RE: **Sunset West-Unit II**
9016 & 9020 Suncrest Rd, 9101 Sunbow Ave. SW
Pad Certification for lots 16, 26 & 27 - Approved
Engineers Stamp Date 8/26/10 (M09D004A)
Certification Dated: 10/20/16

**Re: Sunset West Unit II Lots 16, 26 and 27 Grading and Drainage Plan
Engineer's Stamp date 8-26-10 (M09/D004A)**

SUBJECT: *SUNSET WEST, UNIT 2*
TEMPORARY RETENTION POND RECLAMATION IMPROVEMENTS
L09/D004A
CPN 499182

**Re: Sunset West Unit II Lots 16, 26 and 27 Grading and Drainage Plan
Engineer's Stamp date 7-26-10 (M09/D004A)**

SUNSET WEST UNIT II LOTS 16, 26 AND 27
GRADING AND DRAINAGE PLAN

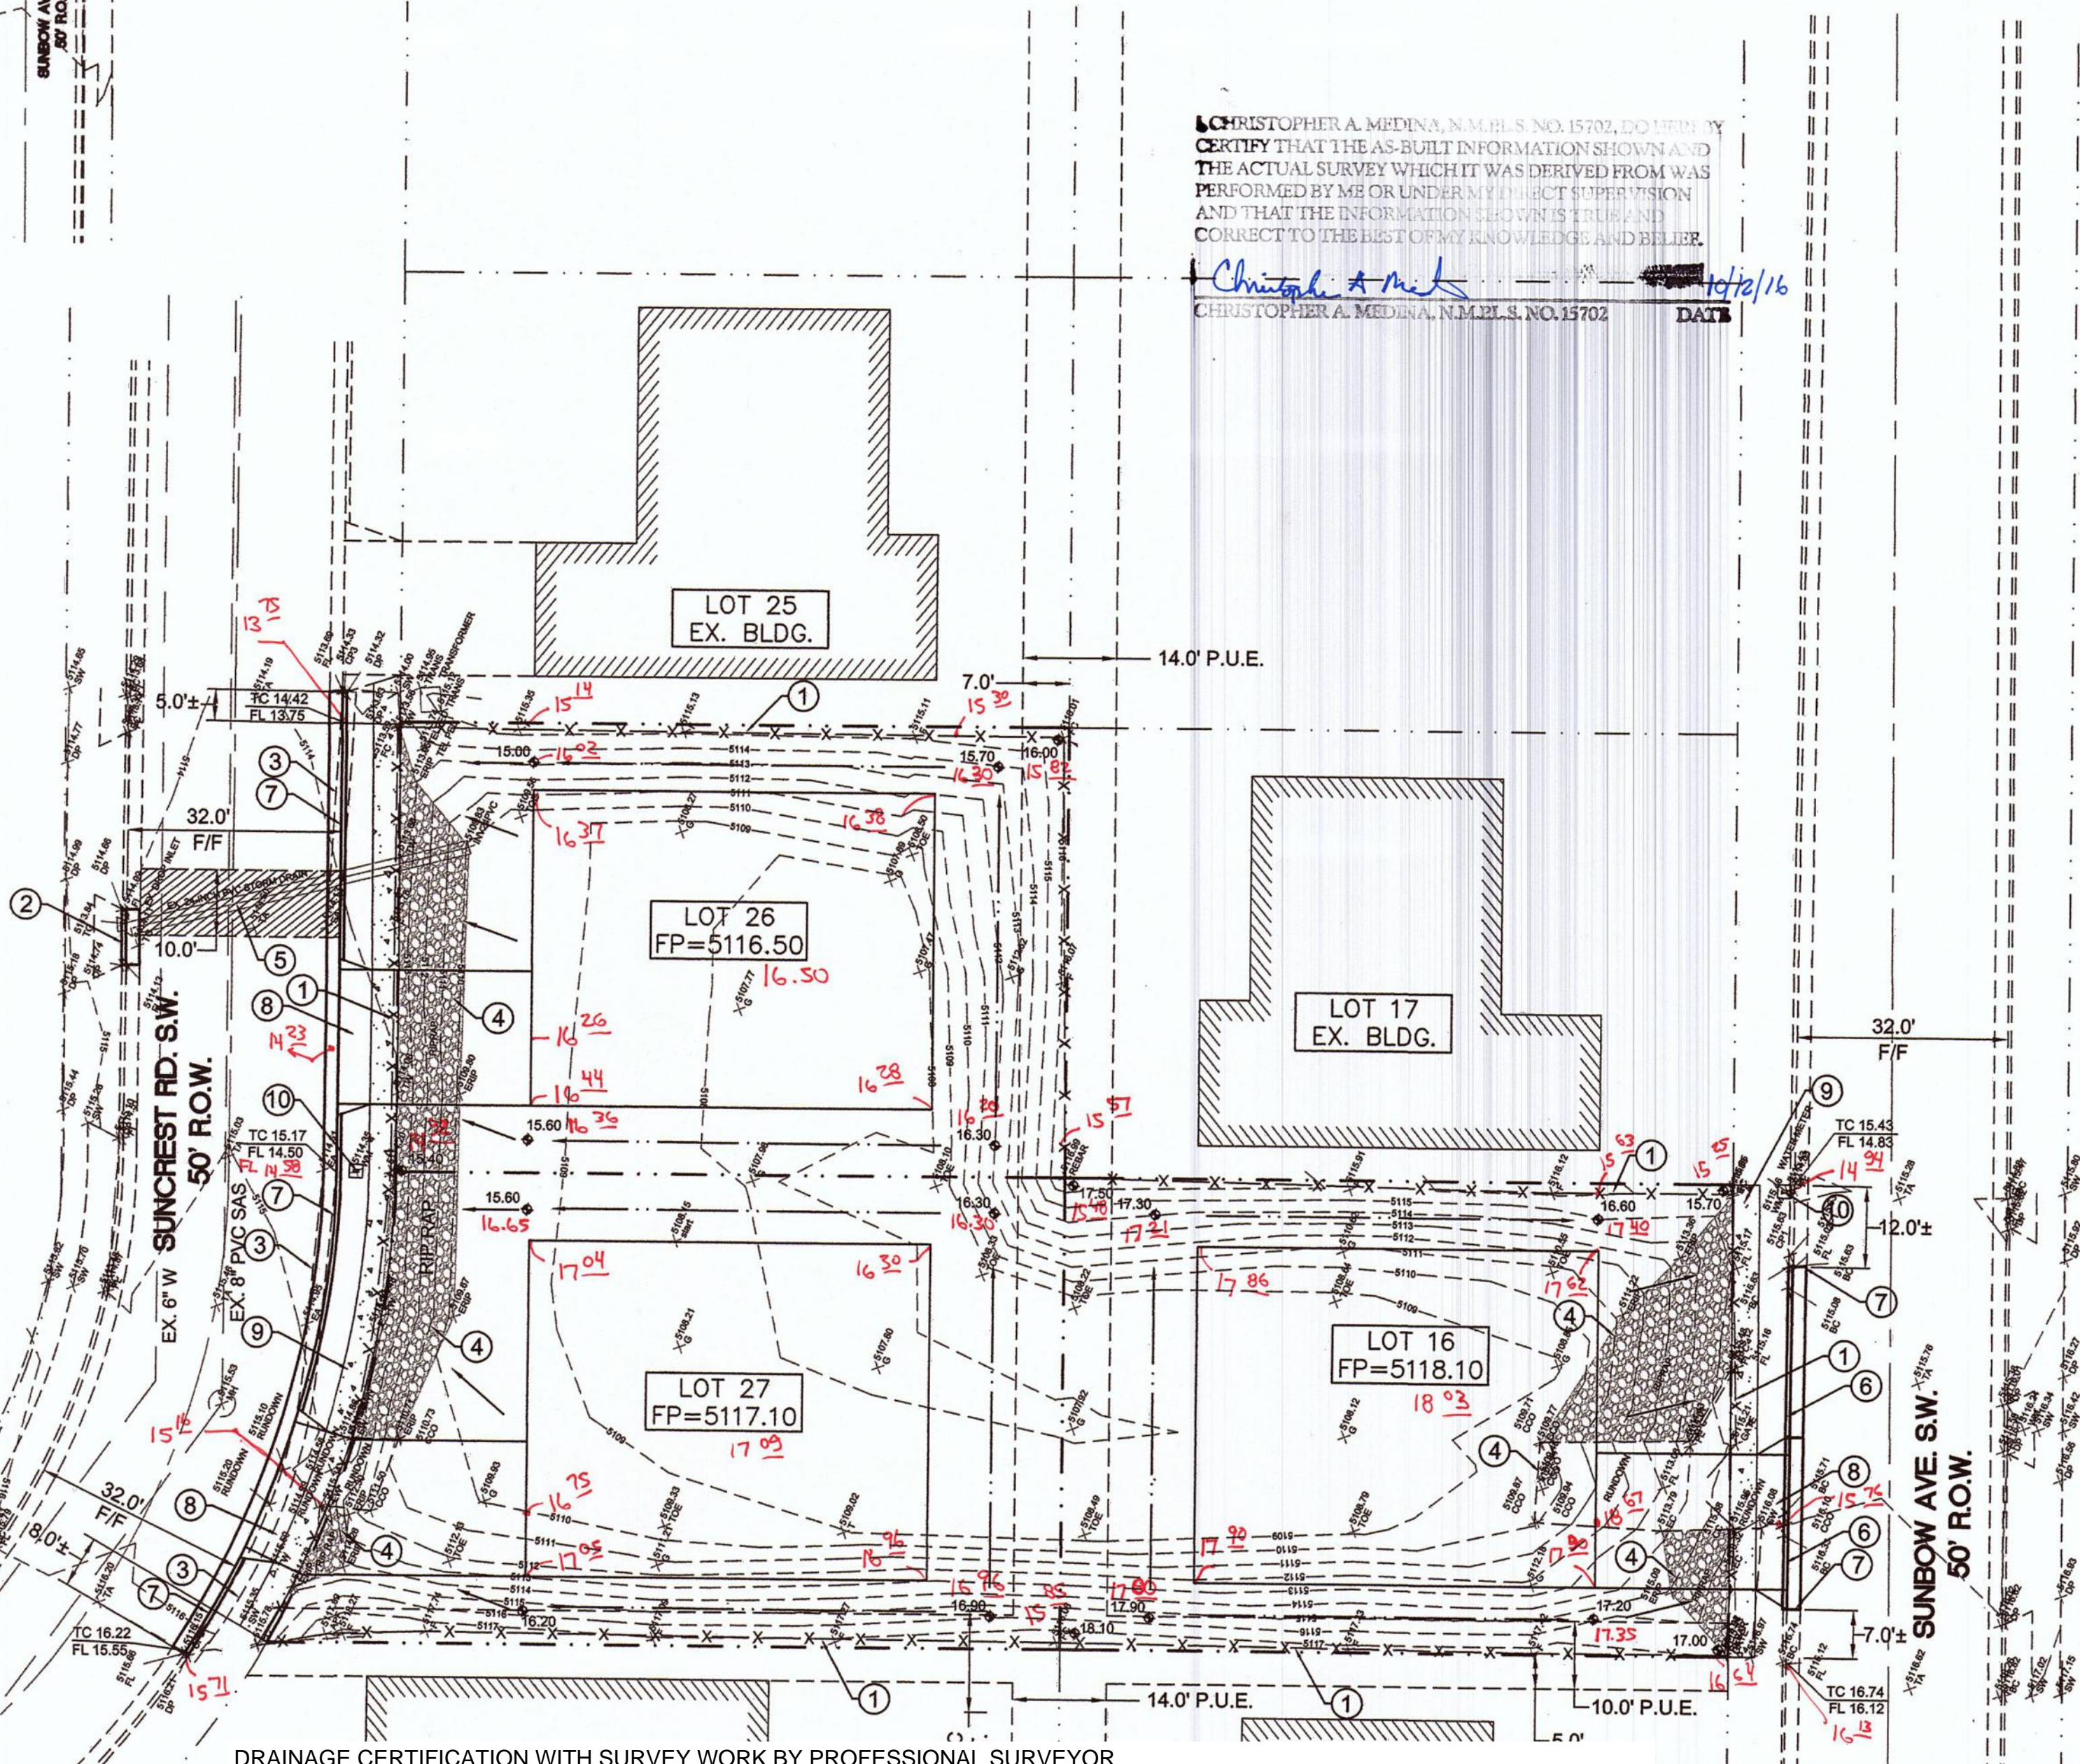
- Provide as-builts for the downstream storm drain.
- It appears that 90th street does not have the capacity if the pond is removed. 90th Street has not changed since the subdivision was built with the pond. The Work Order CPN 4991.90 shows a 25 foot section curb face to edge with a temporary asphalt curb, whereas your submittal specifies 32 ft face to face with standard curb and gutter on both sides.
- It appears that Keyed Note 10 is not required.
- It appears the eastern callout for Keyed Note 6 is extraneous.

1. We understand that Work Order will not be issued until completion of the 86th/Sage Storm Drainage Project.
2. We propose to construct an earthen berm and repair the existing asphalt curb along the east side of 90th street to improve street carrying capacity. See attached calculations and details.
3. The Keyed Notes have been revised to identify public-vs-private work items.
